From: Driver, Tricia <Tricia.Driver@ENWL.co.uk>
Sent: 31 July 2014 08:03
To: planning
Subject: Your Ref NC2/3/2014/0618 (Contact Sarah Westwood) Our Ref PA1856

Erection of 10 Dwellings at Land off Chatburn Old Road, Chatburn

We have considered the above planning application submitted on 25 July 2014 and find it could have an impact on our infrastructure.

Project: (No: Jac.605.1615.GH)	
Proposed residential development at land off Chatburn Old Road Chatburn Clitheroe BB7 4QG	
Title: Proposed Site Layout with Topo Overlay	
Drawing No: Jac/605/1615/08	Drawn: PF
Client: Mr R Jackson	
Date: June 2014	Scale: 1:500 @ A3
Amendments:

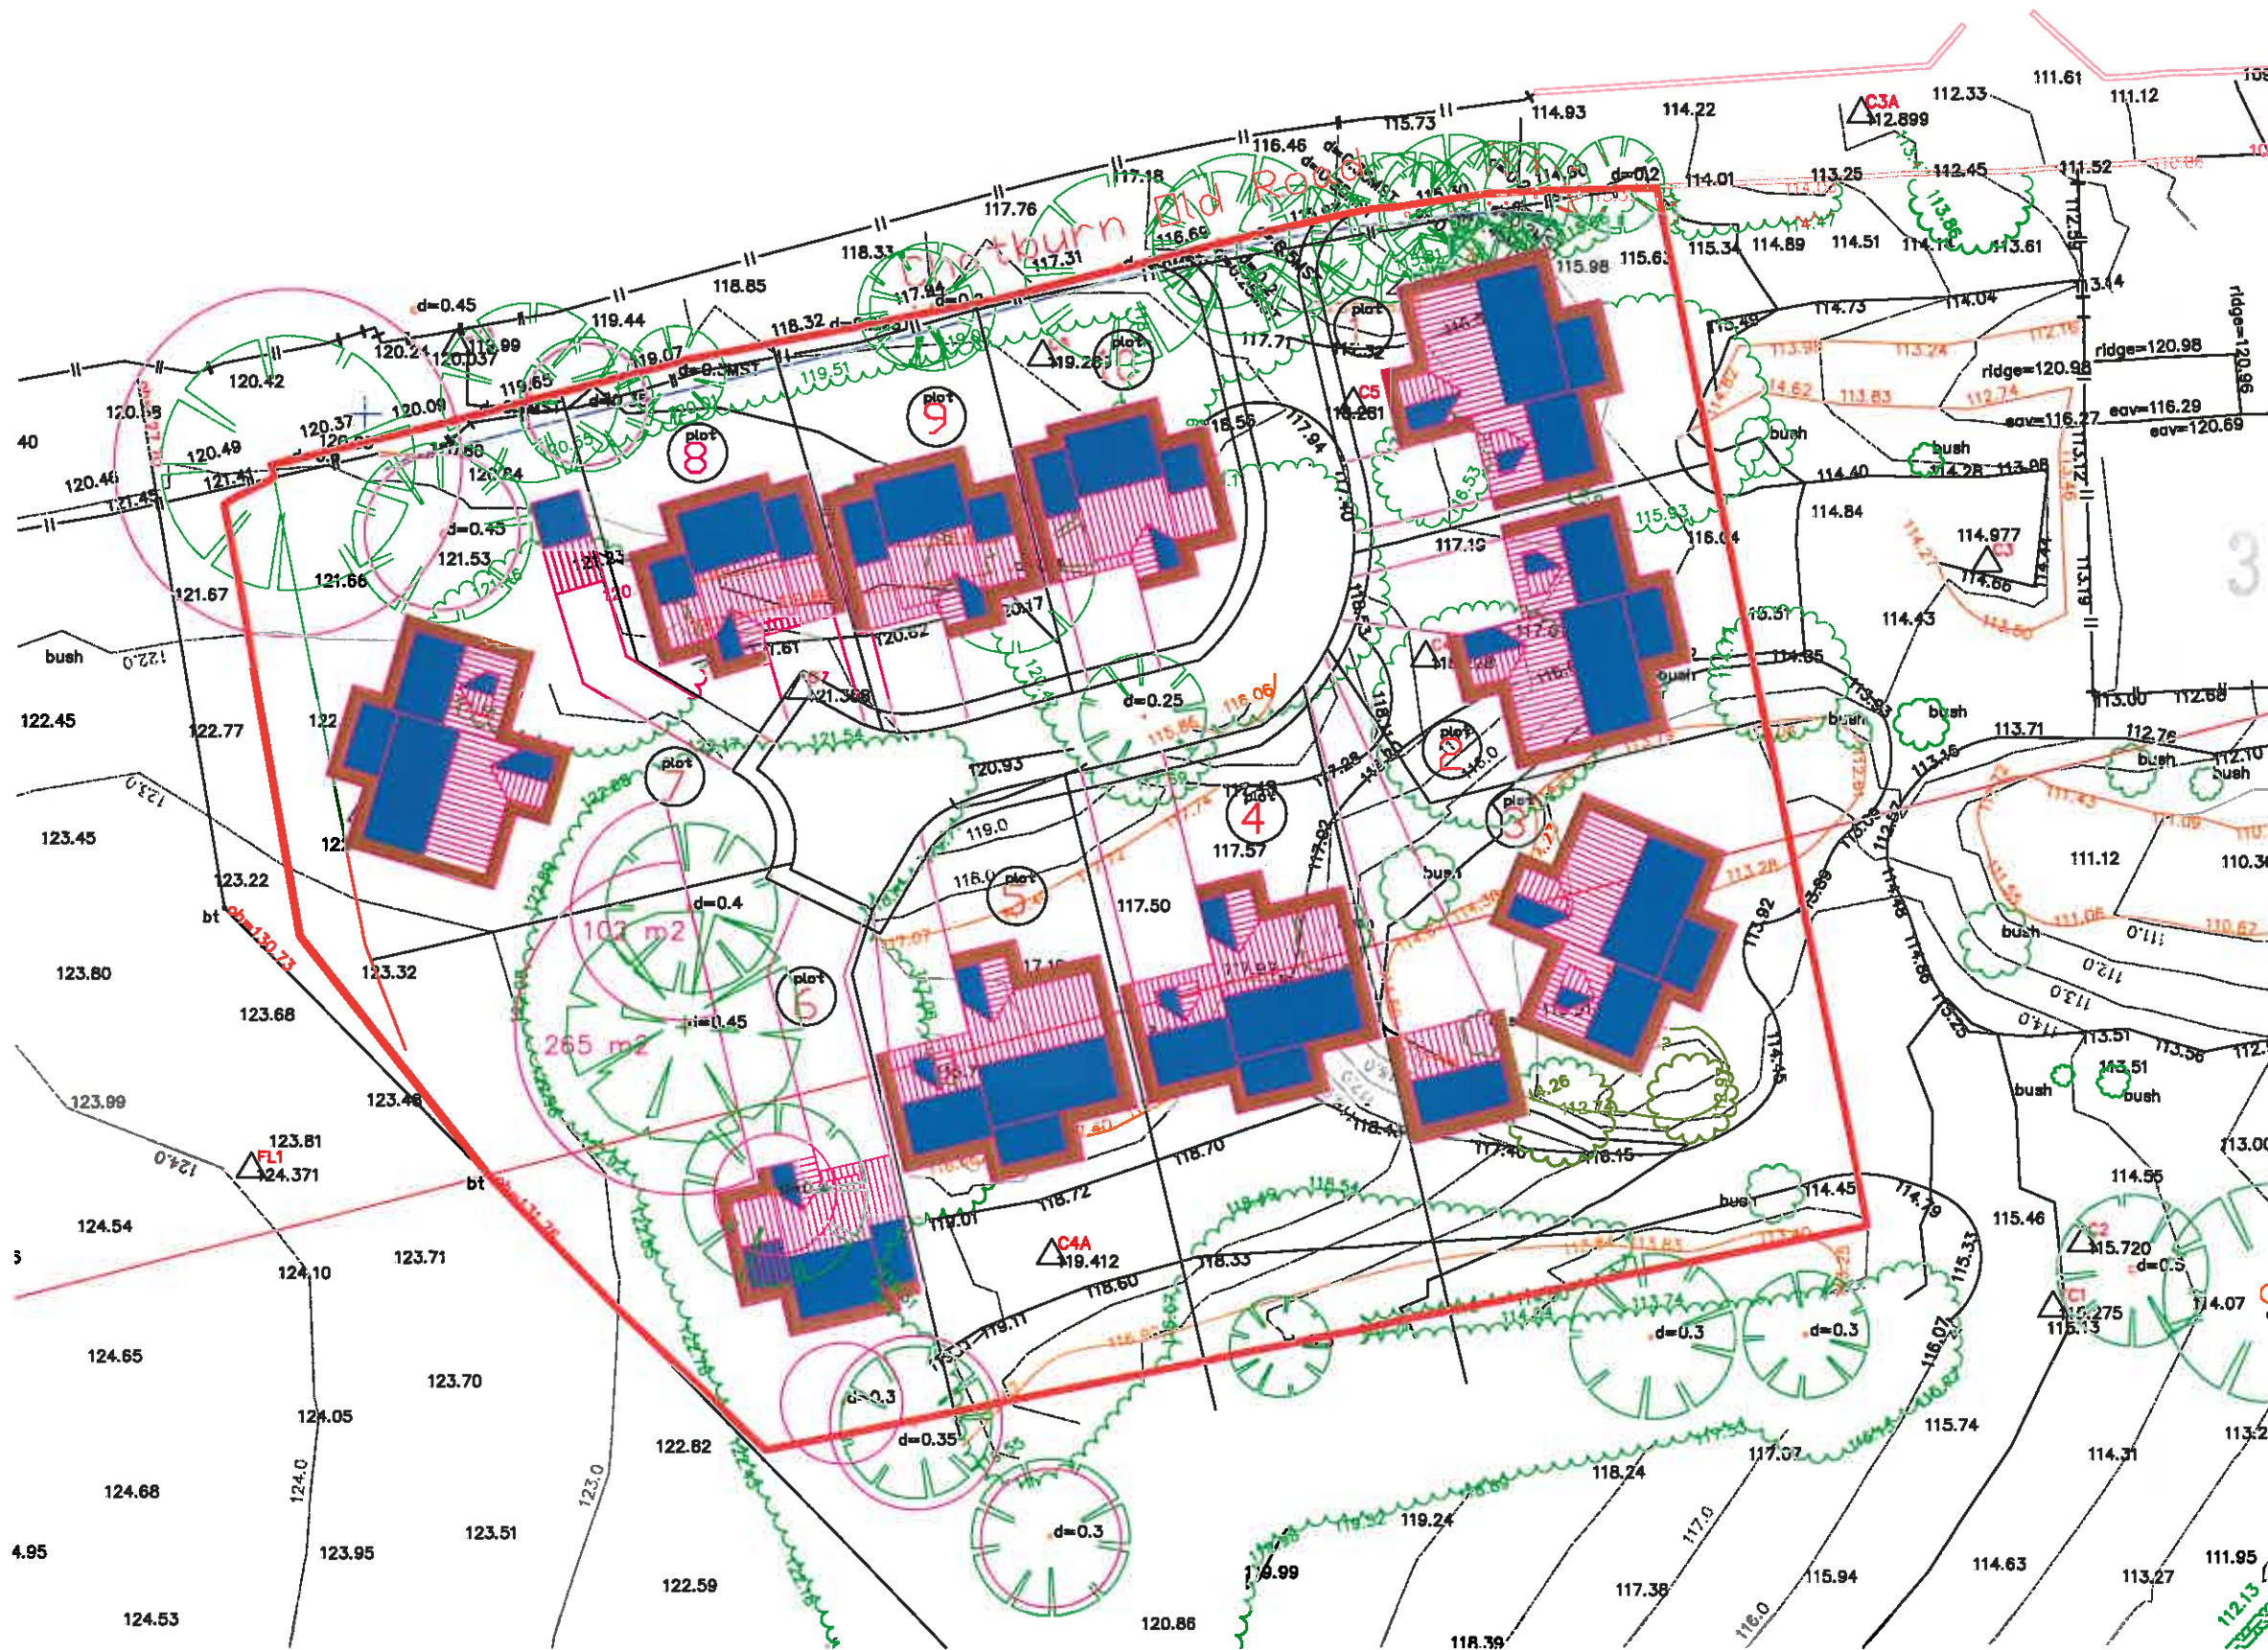
There is an 11kV wood pole line which runs along the west boundary of the site for which ENW may have access rights. Appropriate clearance to the line should also be maintained.
